re:	Geotechnical Response to City Comments Proposed Python Complex - 222 Citigate Drive (Block 13) - Ottawa
to:	Broccolini Construction - Mr. Russell Beach - russell.beach@broccolini.com
to:	Broccolini Construction - Mr. James Lucas - jamesl@broccolini.com
date:	June 2, 2020
file:	PG5284-MEMO.03

# **Grading Plan - Comment 22**

# Grading Plan - Comment 23

SCALE 1:1250

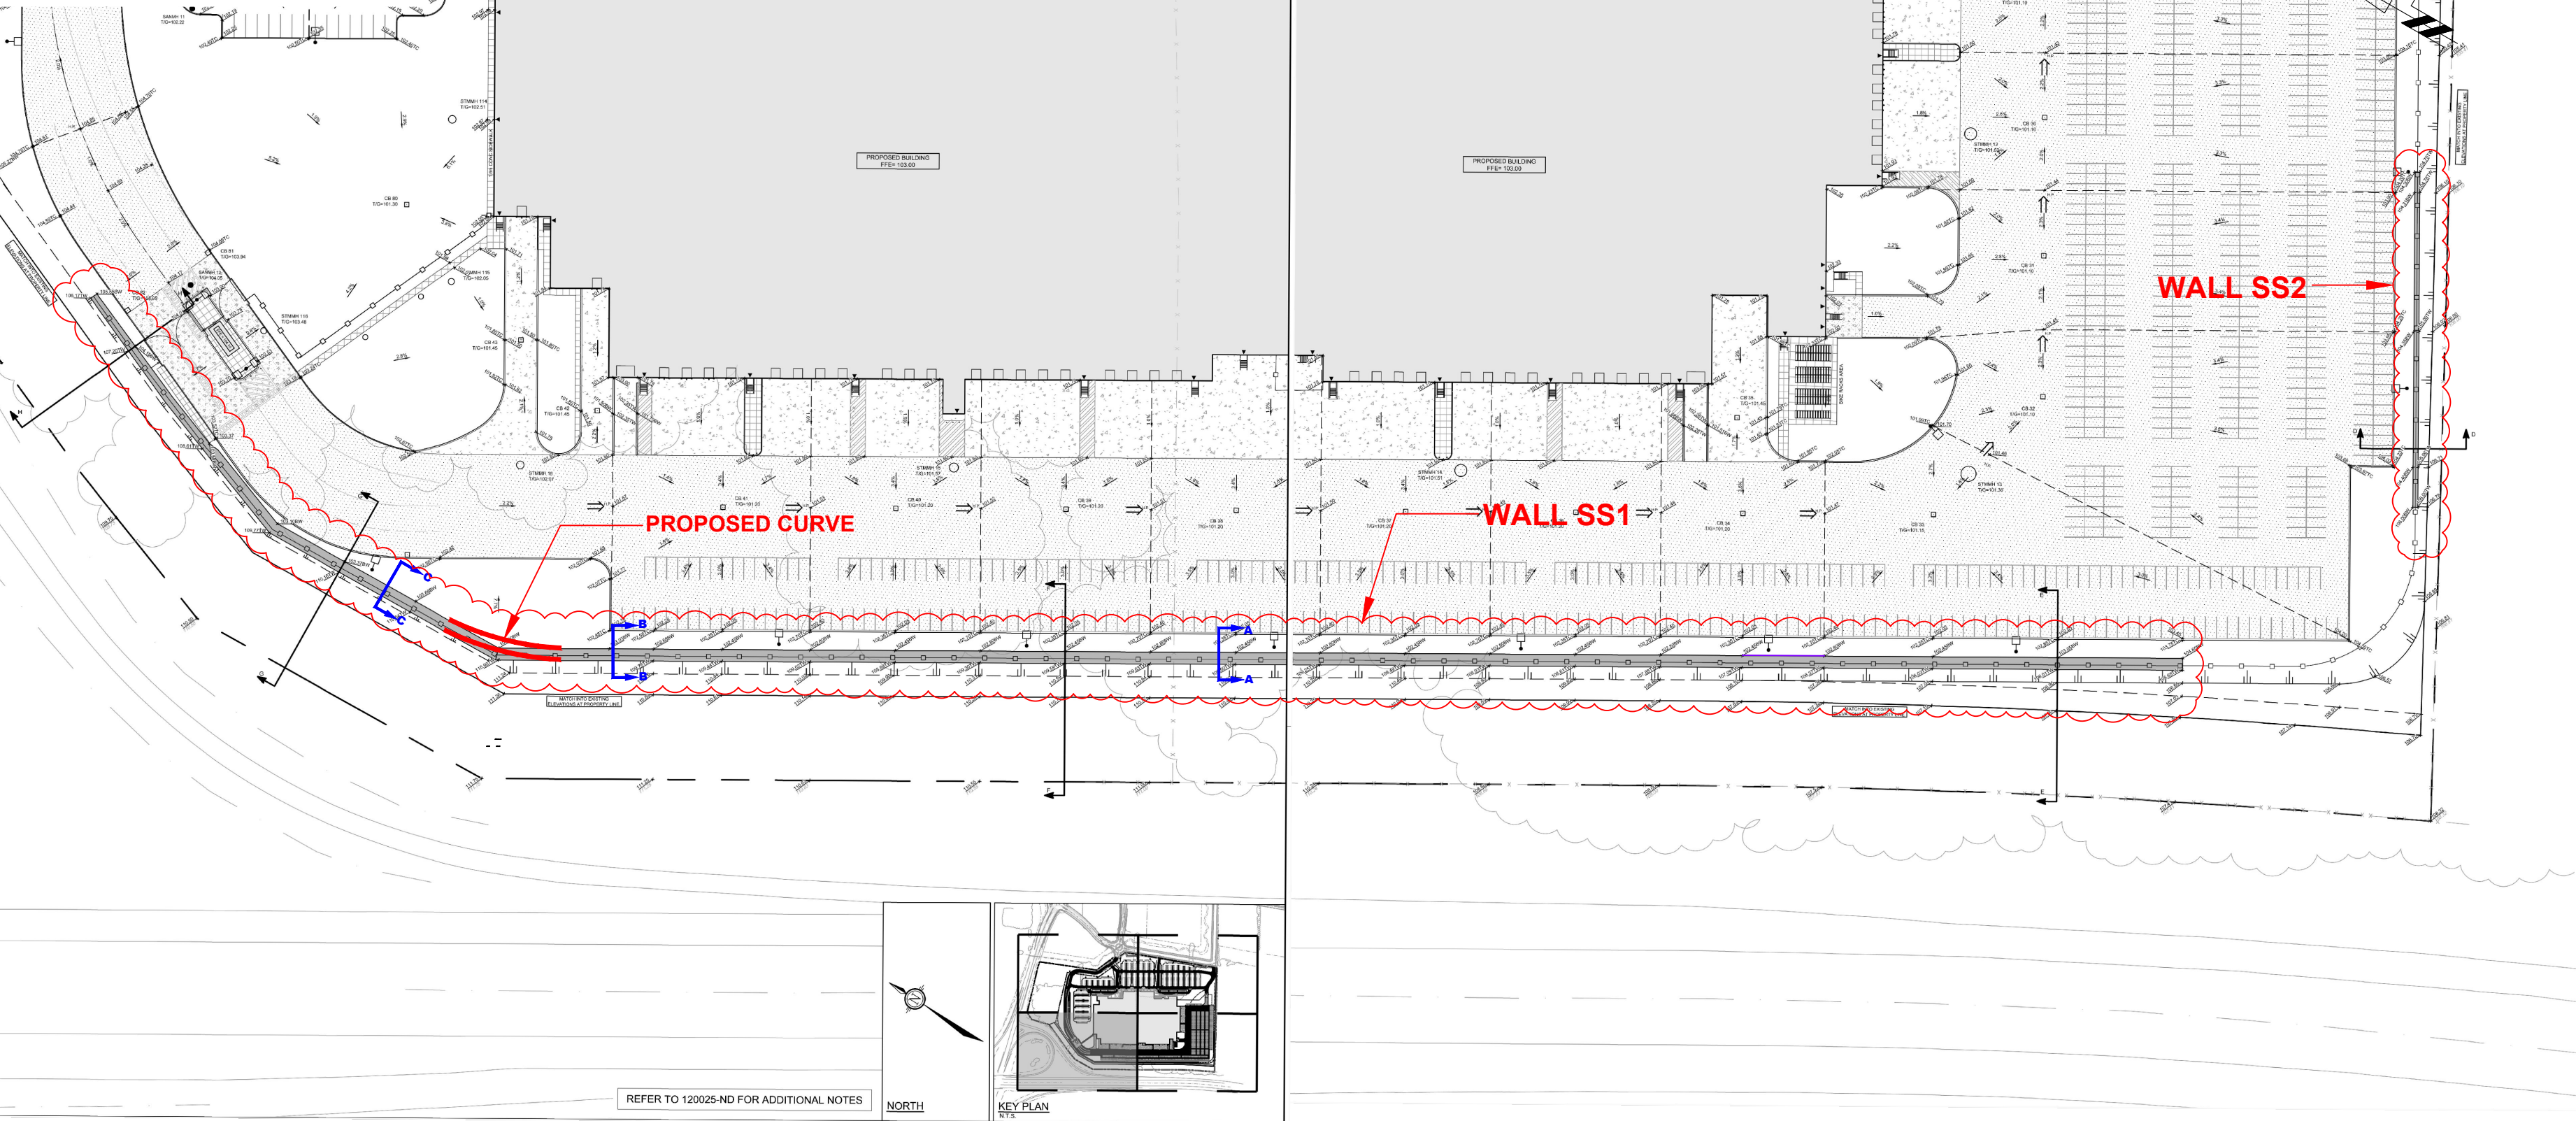
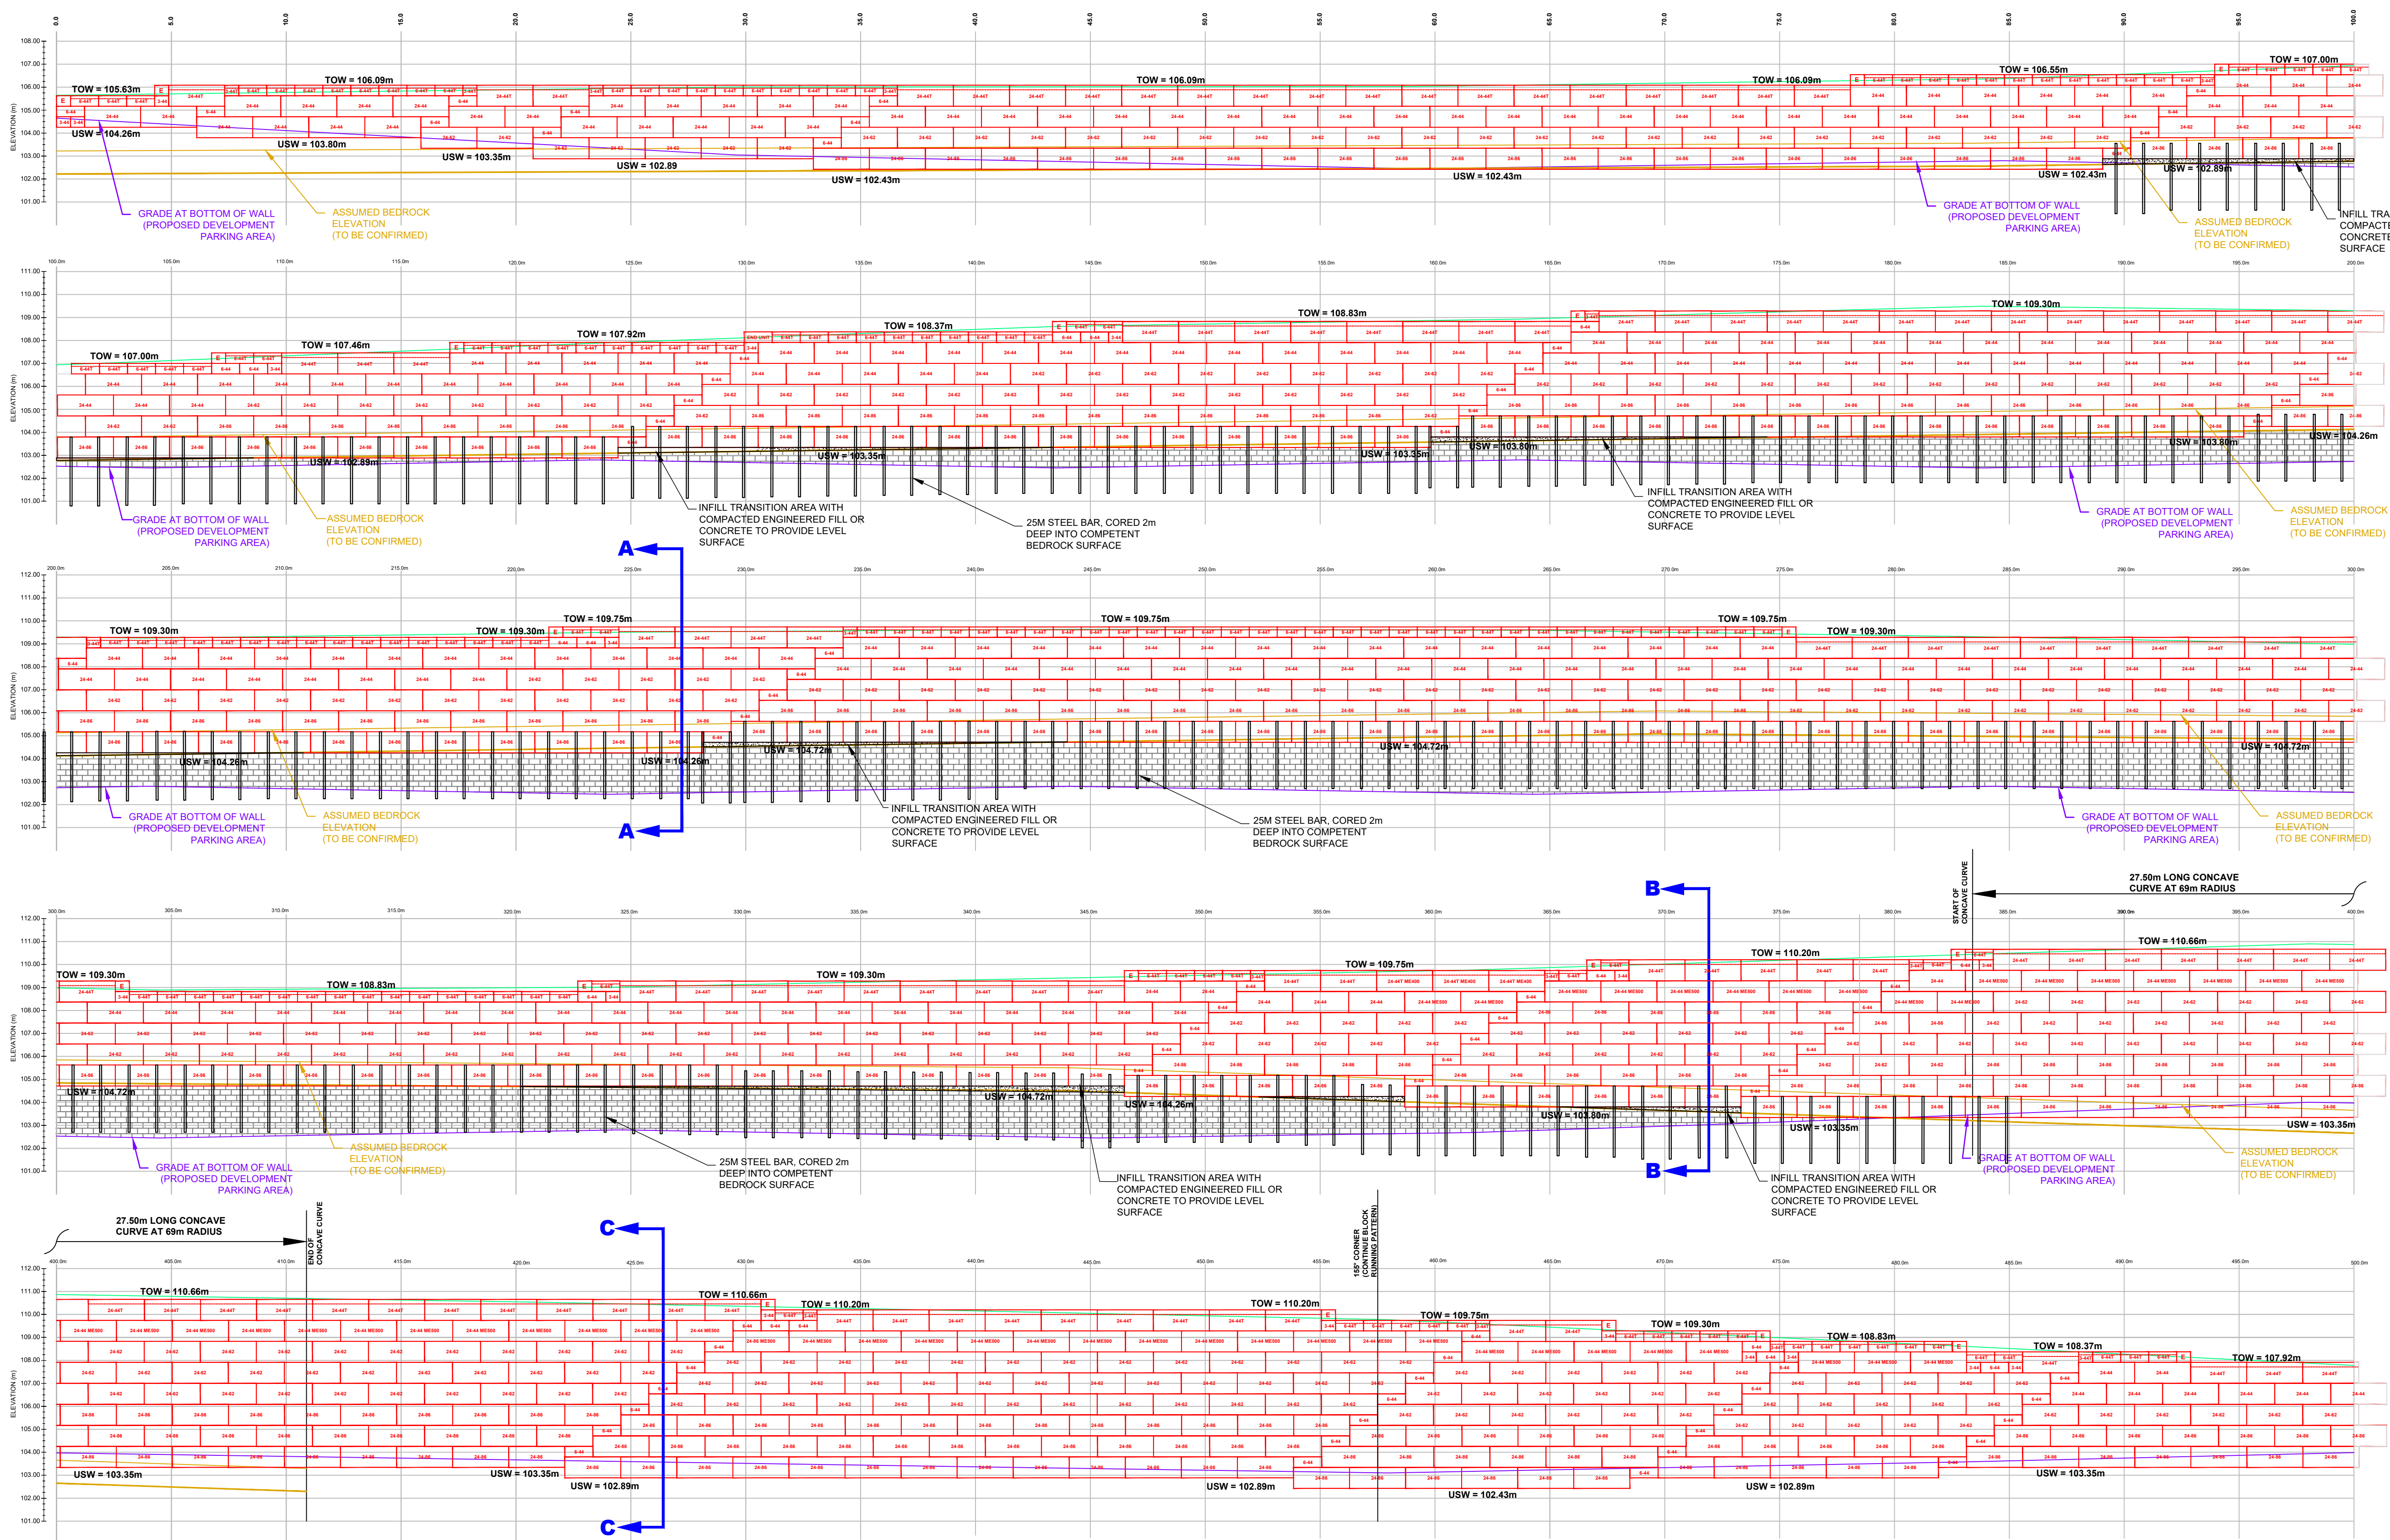
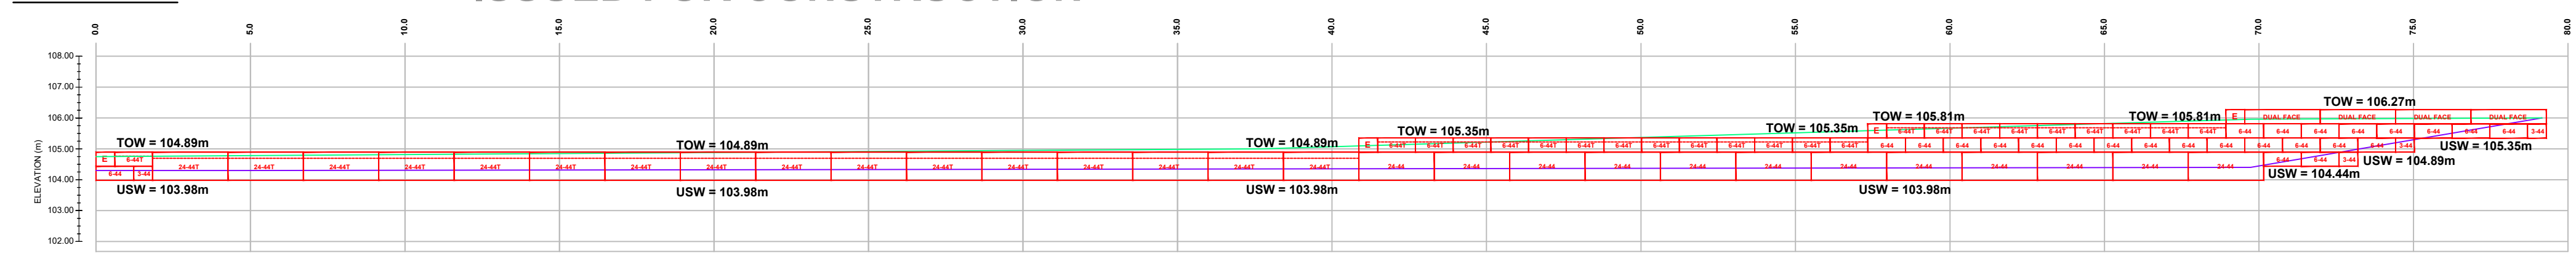
Please include details for the proposed retaining wall. Structural design is required for retaining wall greater than 1.0 in height.

Please refer to Drawing PG5284-2 Stone Strong Retaining Wall Profile - SS1 and SS2 and Drawing PG5284-3 Stone Strong Retaining Wall Design - Wall SS1 and SS2, Revision 1 dated May 14, 2020 enclosed for the design of the proposed retaining walls for the subject site.
